Address: 78 Lingards Road Huddersfield HD7 5HY

| Application number: 2025/91887   |   |
| What is the application for?:    | Variation of condition 2 (plans) of previous permission 2020/93954 for erection |

title:
Proposed Ground Floor and First Floor Plans
drawing status: Planning drawn by: JD checked by: JD
drawing no.: 2510-PL-01-100 rev: -

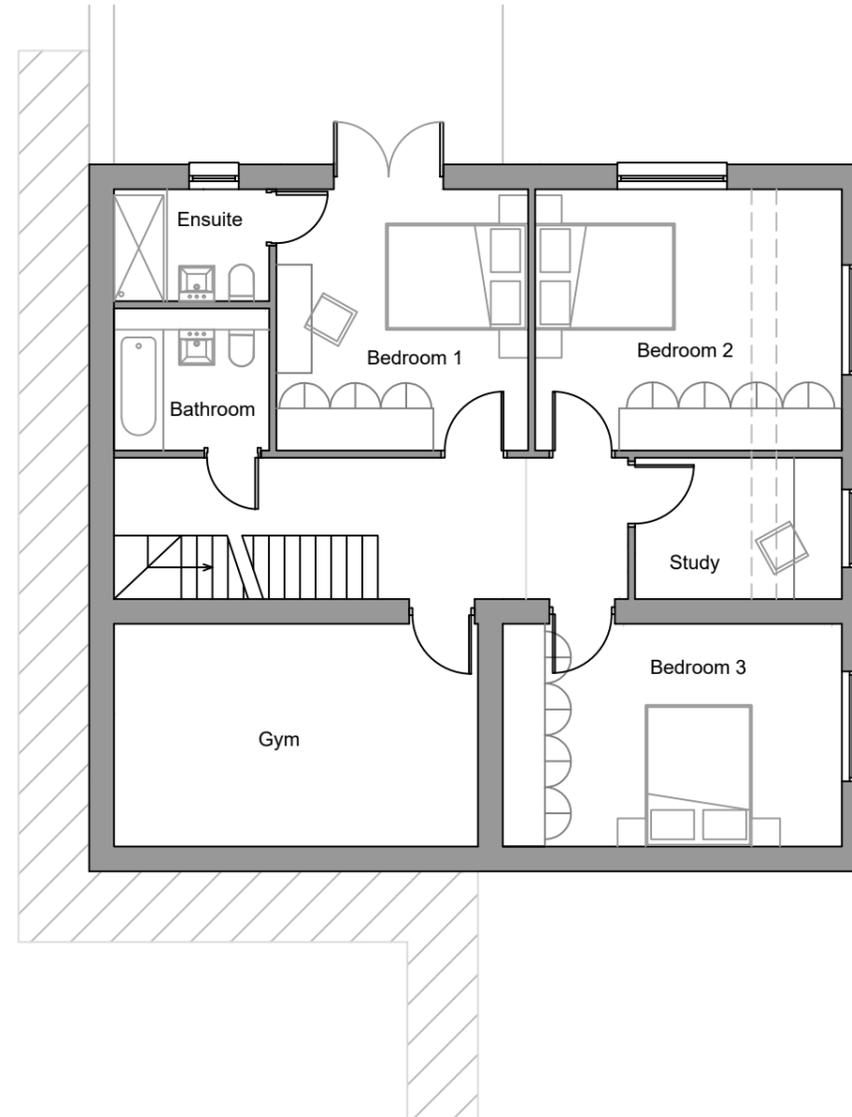
| <p>I object to this variation. The variation wording states that the footprint stays the same and then qualifies it by saying other than the garage and entrance porch. The footprint has increased and the building is no longer in keeping with that initially approved. The developer is using variations/changes on a number of individual plots and then using these variations as support for changes to other plots. These variations are for commercial purposes and at the expense of the existing residents and users of Lingards Road as they are overriding the principles and conditions (many of which have been broken on numerous occasions by the developer, reported to planning enforcement with no timely action taken) of the original application.</p> |    |
